24 November 2016

File Number: 2016/617649  
Our Ref: R/2016/26/A

**State Significant Development 16\_7881 – Sydney Opera House Building  
Renewal Program - Function Centre and Related Works**

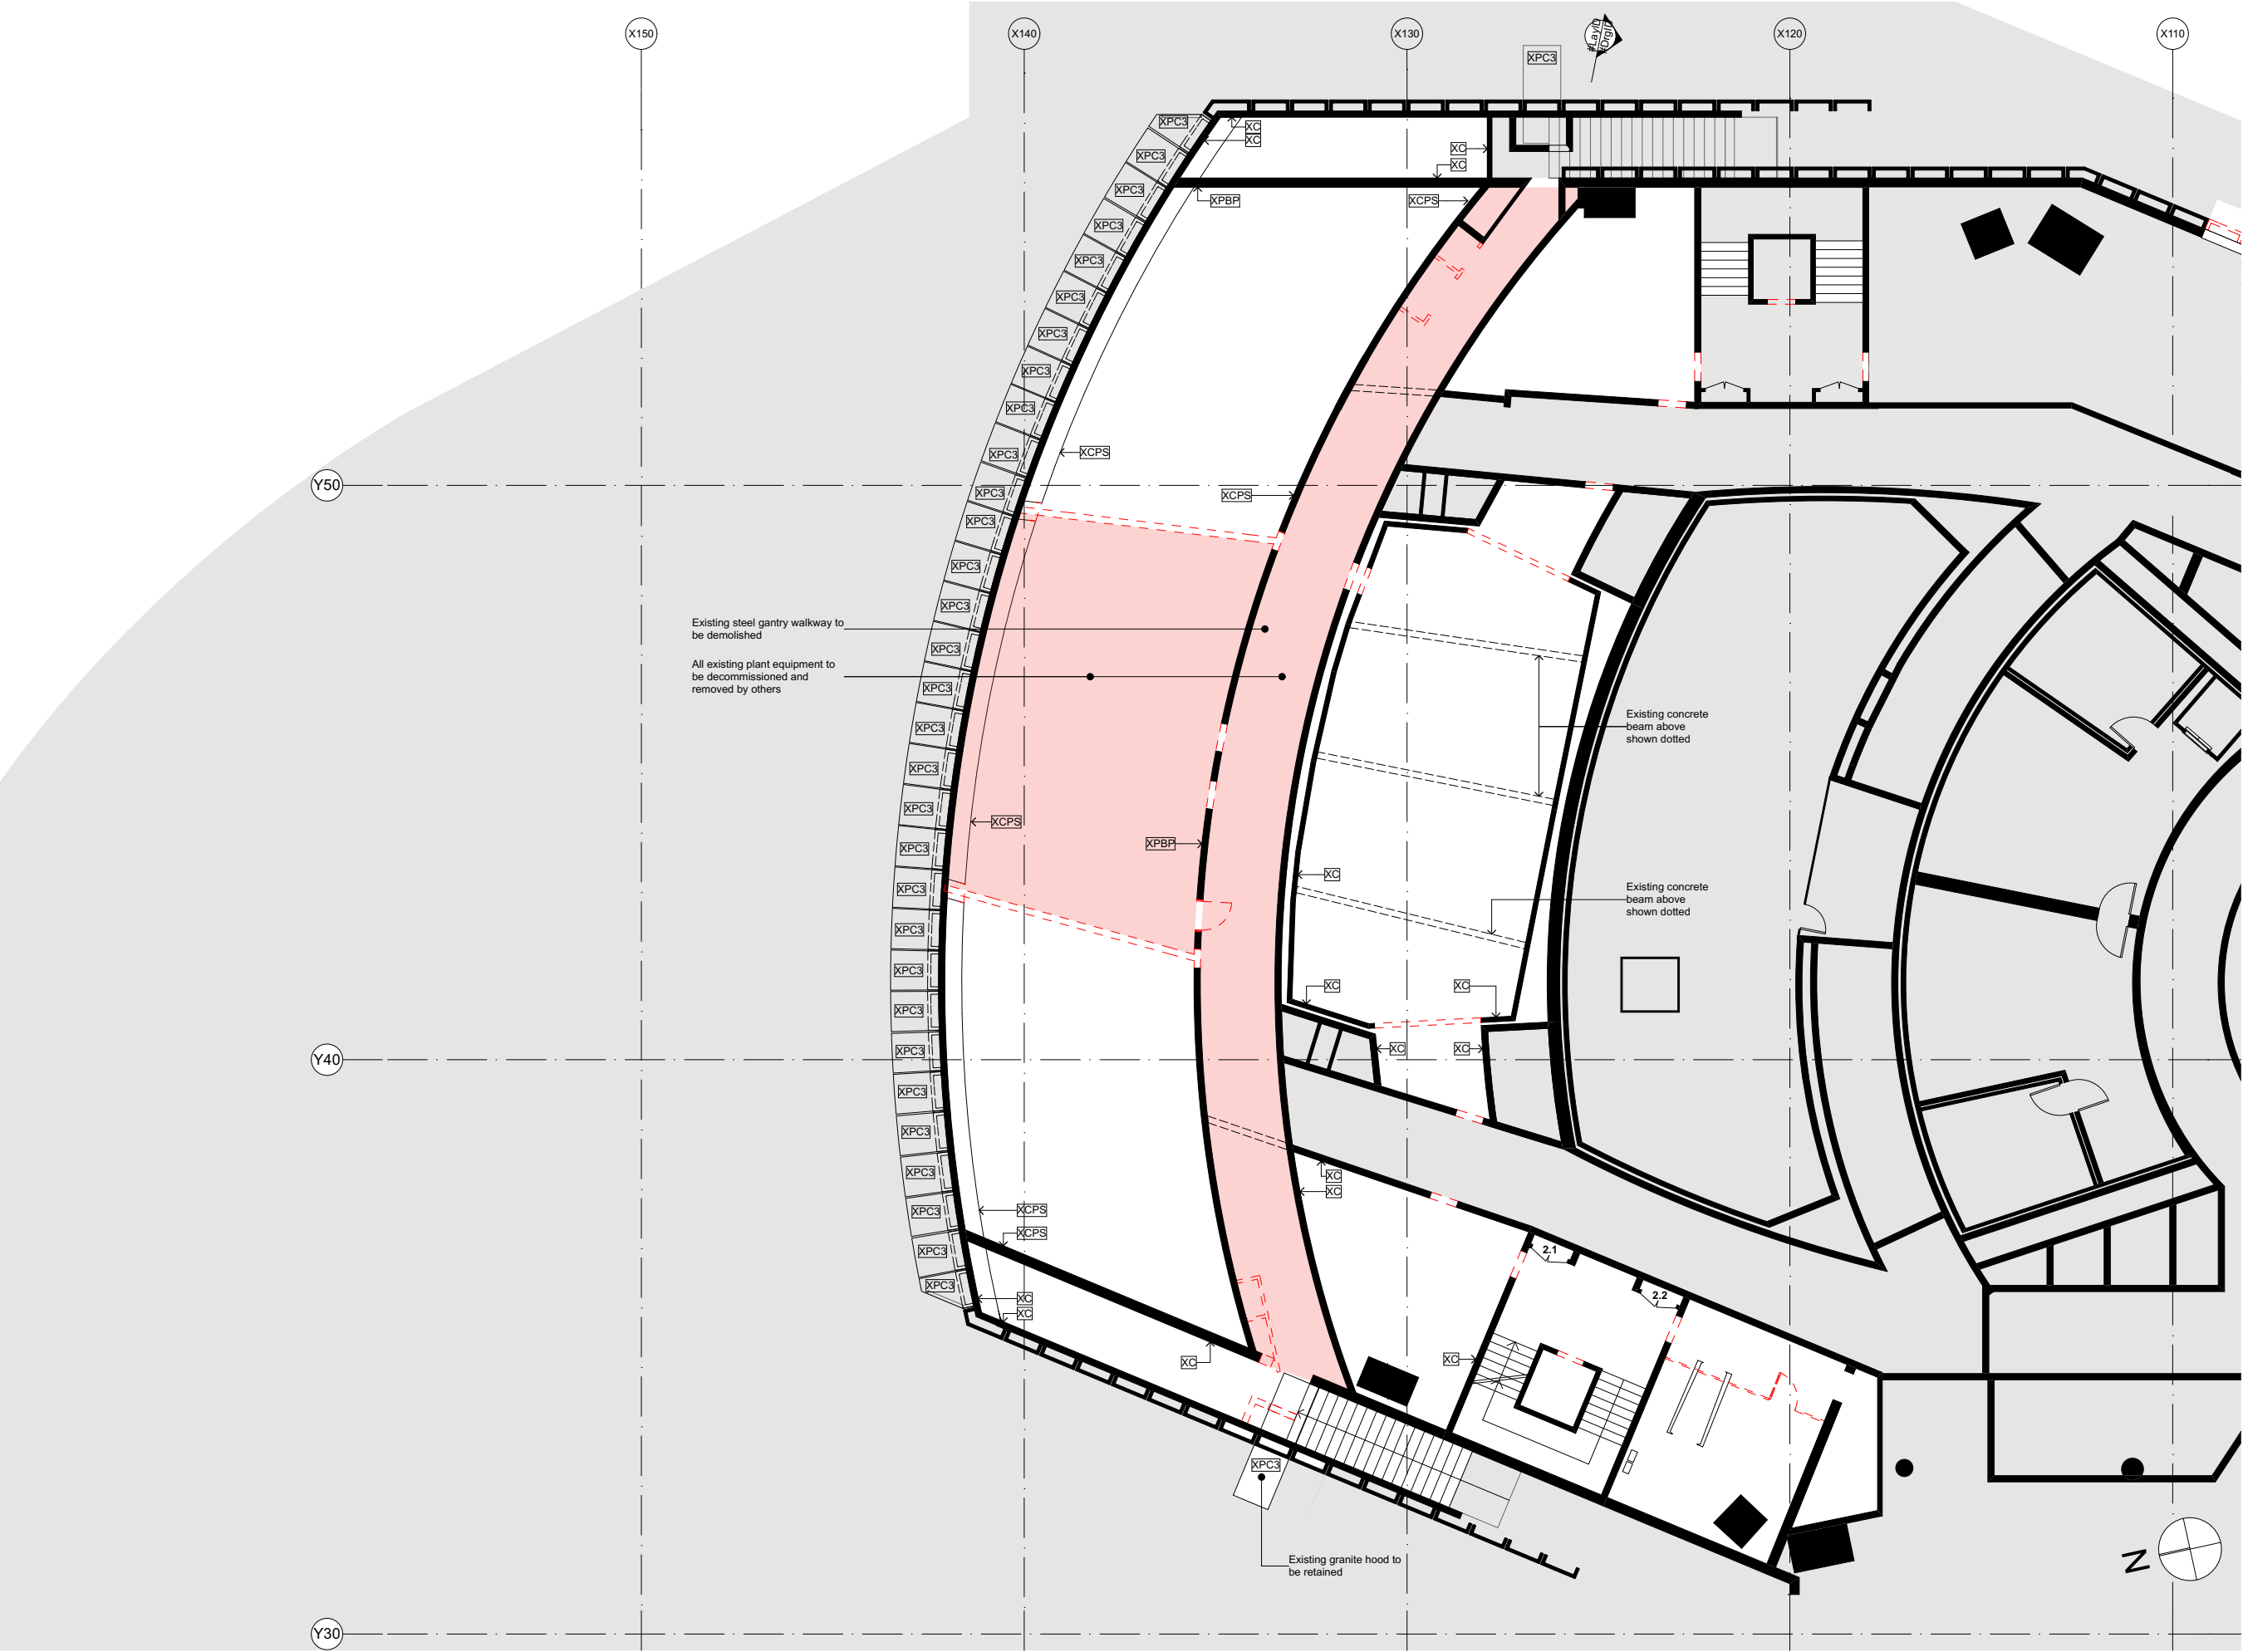
The proposed function centre is proposed to be expanded to occupy the whole of the northern frontage of the podium. The eastern part of this area originally accommodated the Harbourside restaurant complex, which is graded in the CMP 2003 as (B).

The formation of an enlarged function room is dependent upon the partial removal of the curved walls of the main corridor that are graded as (B). The extent of removal requires careful consideration as it is an irreversible change. An enlargement of the original opening in the western wall of the eastern podium is also proposed. In our opinion, this will diminish the drama of this elevation with its singular narrow opening, and is therefore not supportable.

In addition, the proposed expansion of the function centre and associated demolition works will prevent any future reinstatement of the original Harbourside restaurant. This is a loss to the community and to the significance of the place.

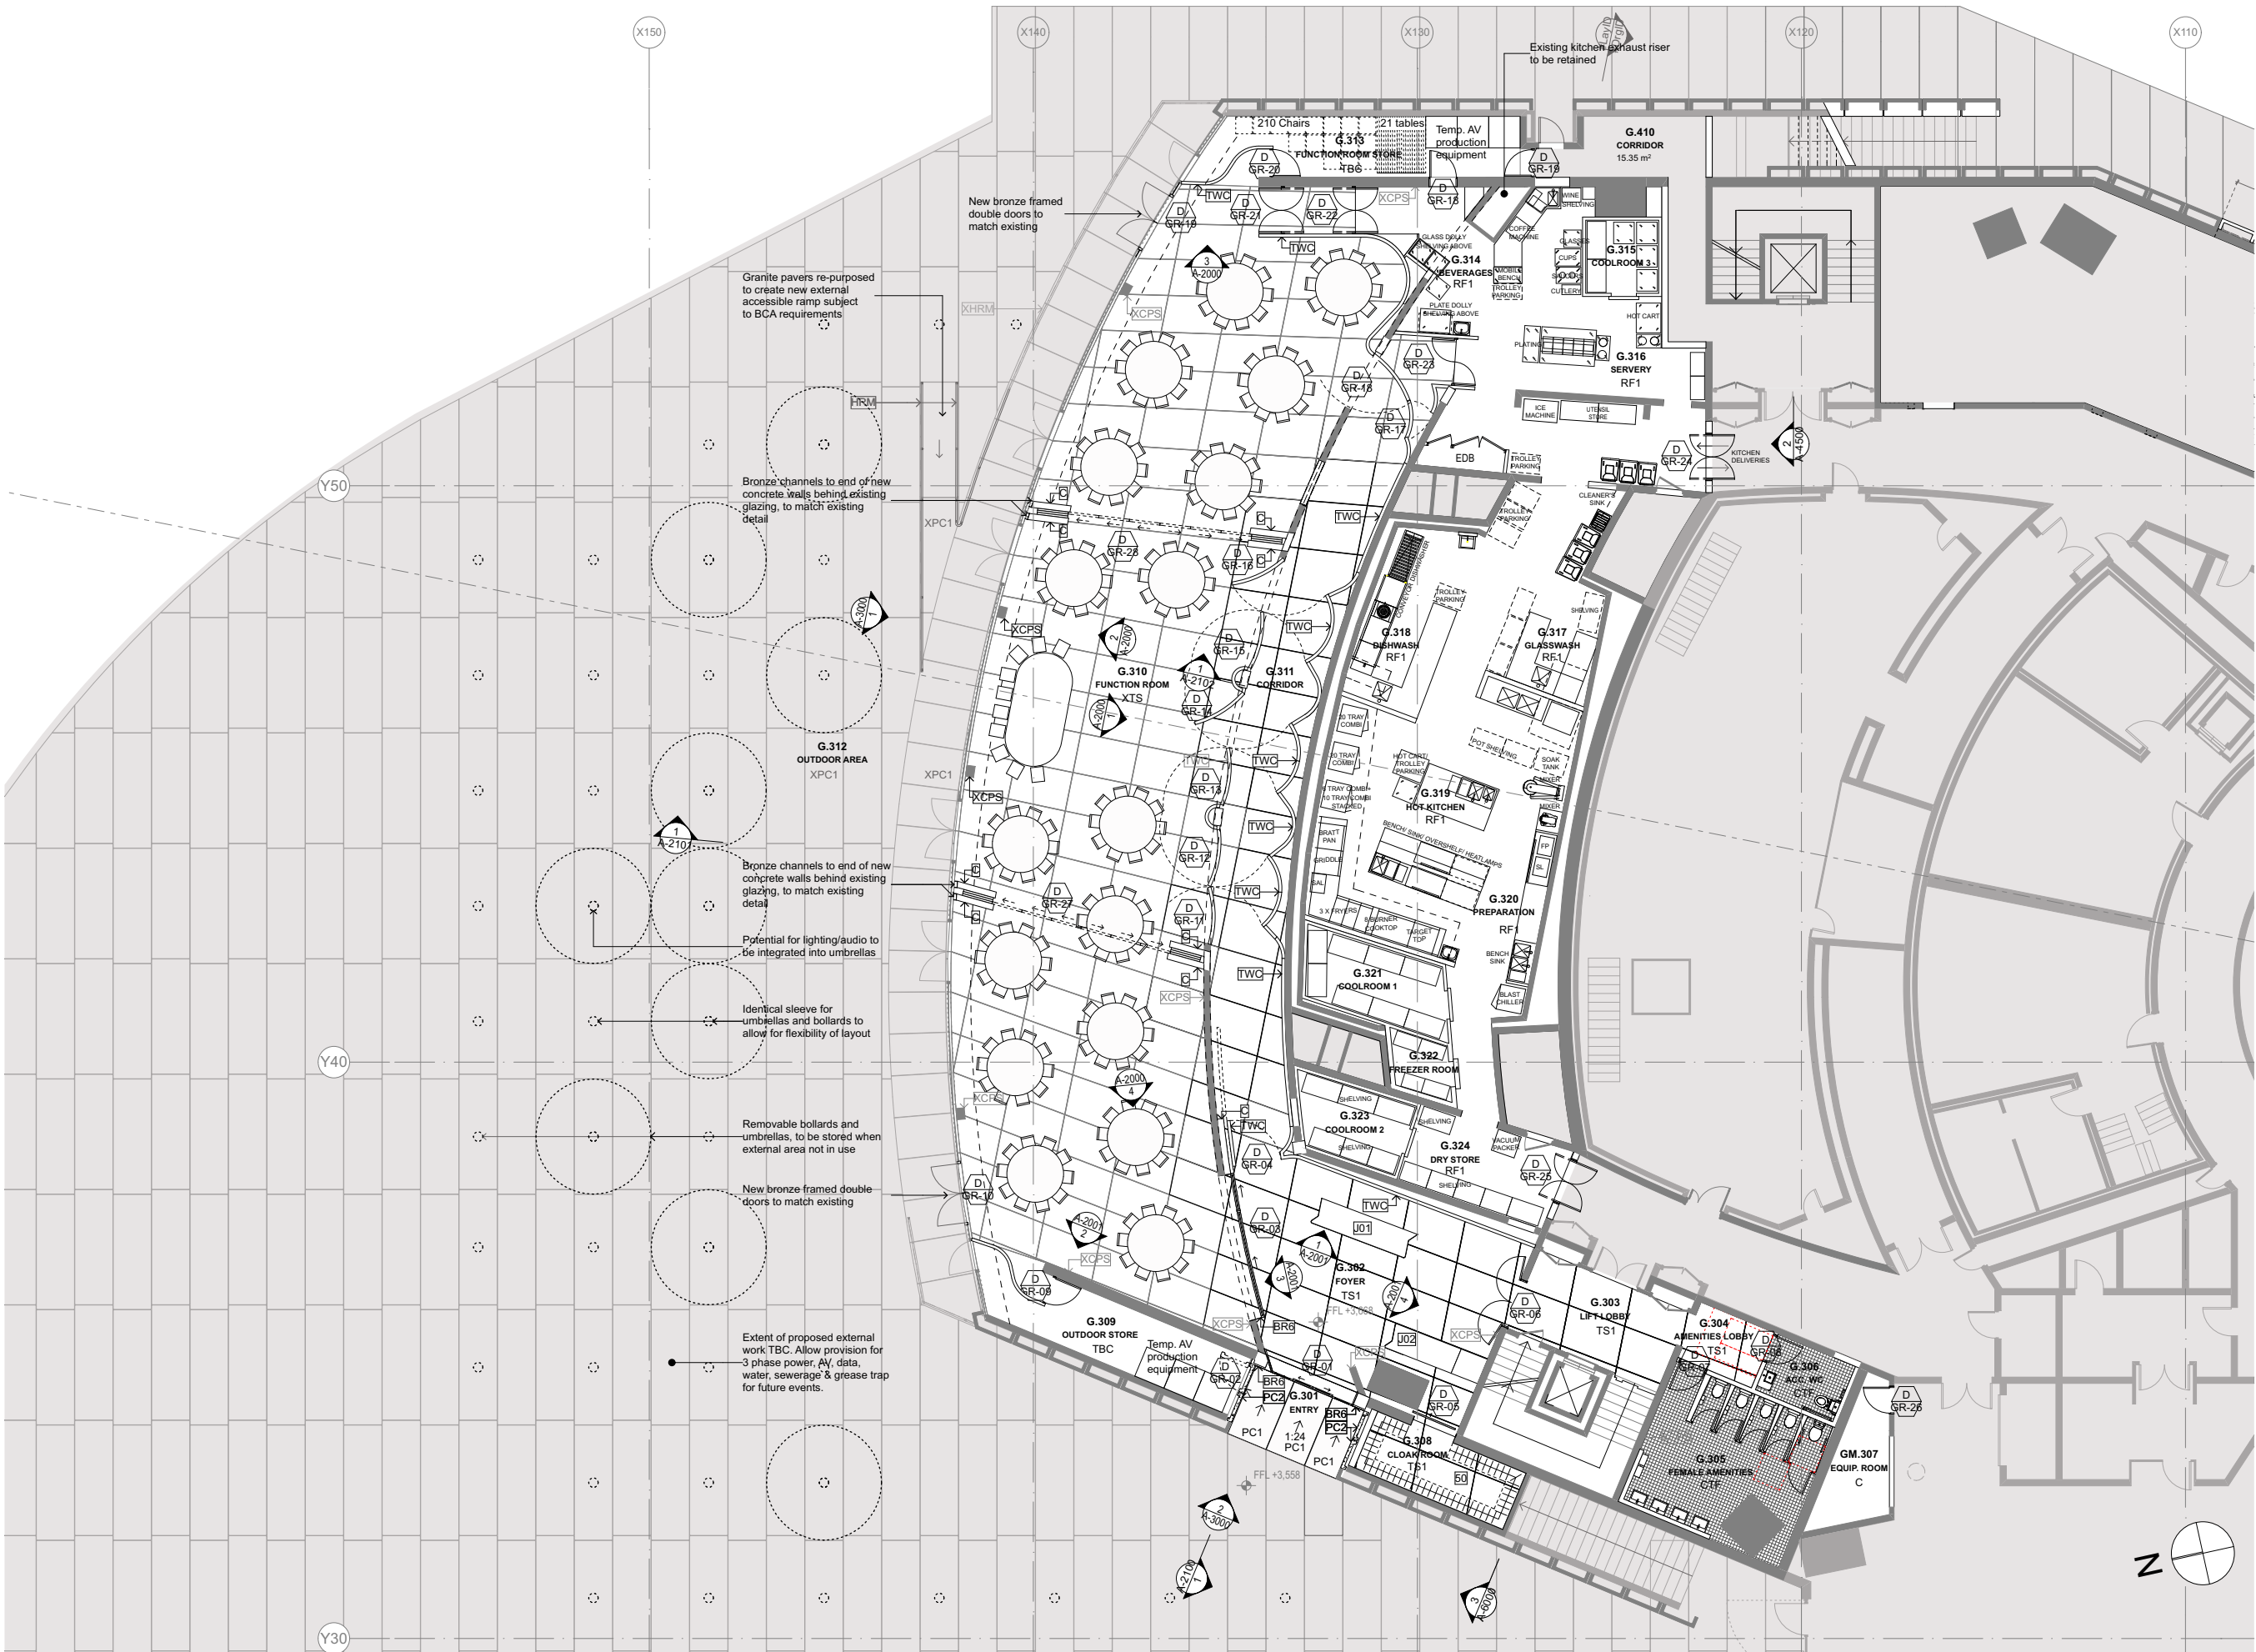
The CMP 2003 and the drawings appear to use differing descriptions for the levels of the building, making it difficult to cross reference. For example, it is assumed that Level +30 in the CMP 2003 is the Ground Floor Plan (+12) in the drawings.

If there is an inconsistency, it is recommended that the drawings be amended to use the same naming convention as the CMP 2003.
